Plan Review

**EPC Planning & Community
Development Department**

**CLOVERLEAF FILING NO. 2
LOT NO. 58**

**CLOVERLEAF FILING NO. 2  
LOT NO. 58**

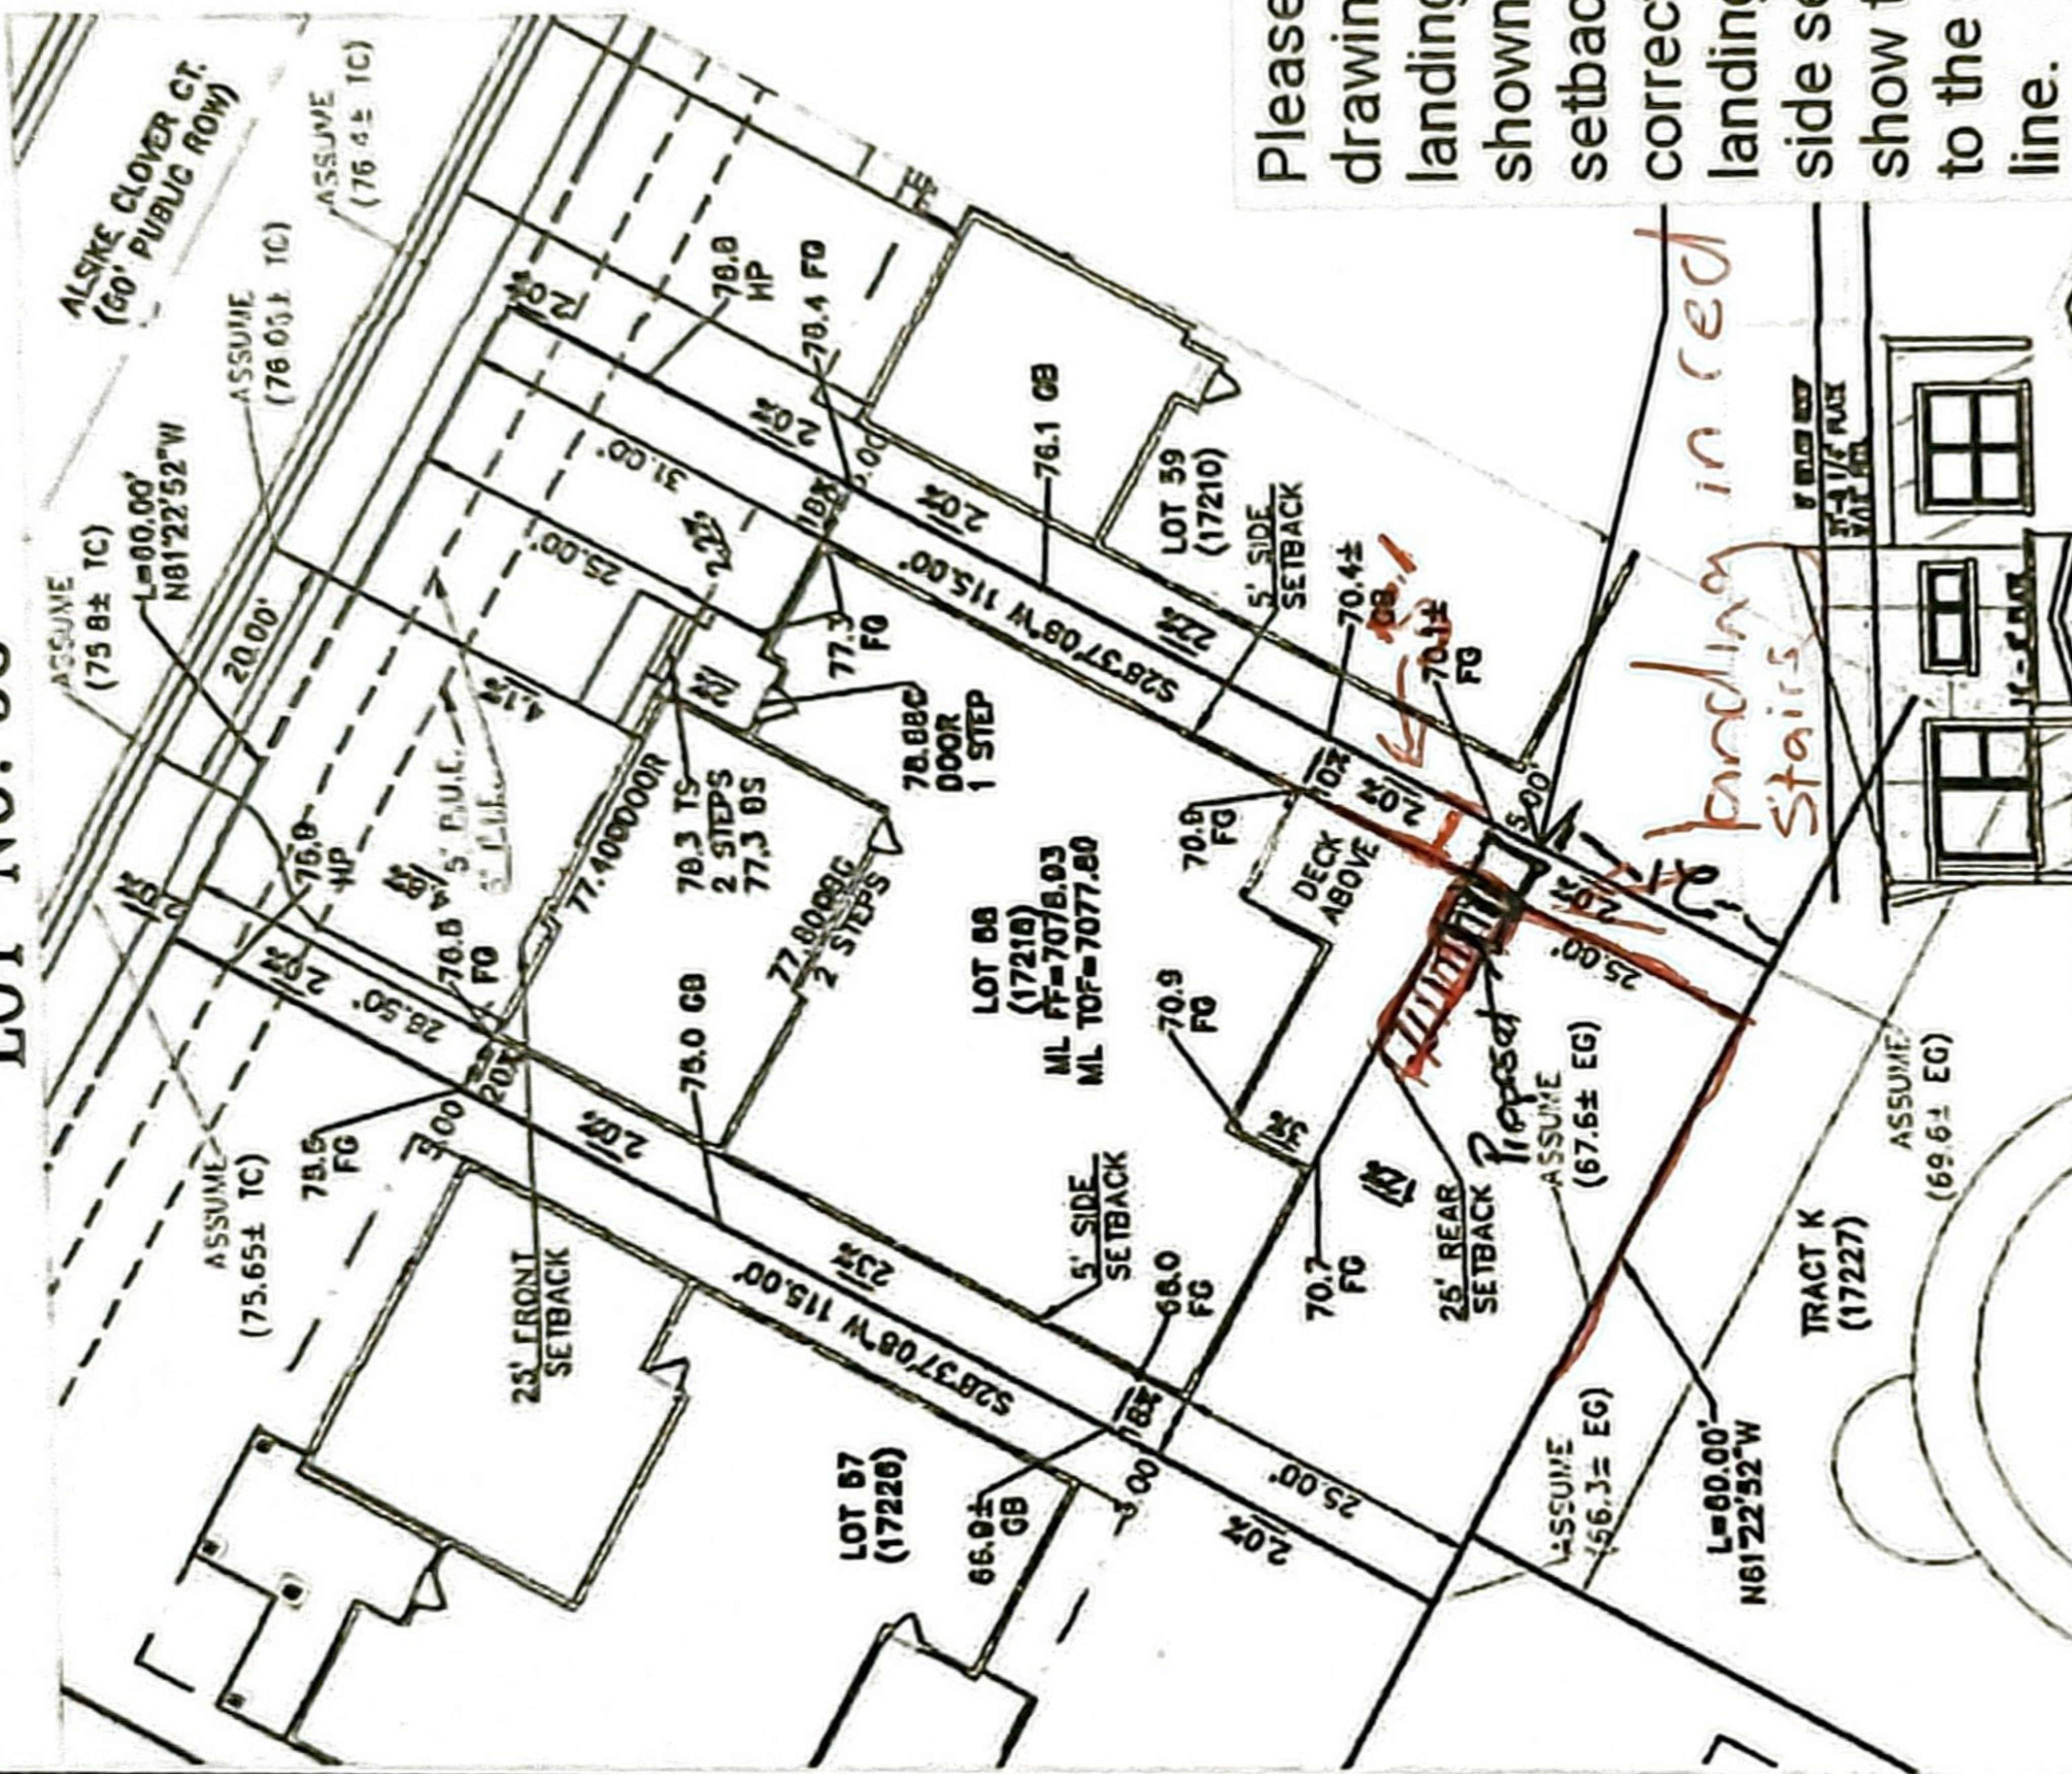
~~Please add labels to drawing. Is this the landing? If so, it is shown within the side setback. Please correct so that the landing is outside the side setback and show the dimensions to the side property line.~~

landings in red stairs

Resolved - dotsandstrom
 08/01/2024 2:04:23 PM
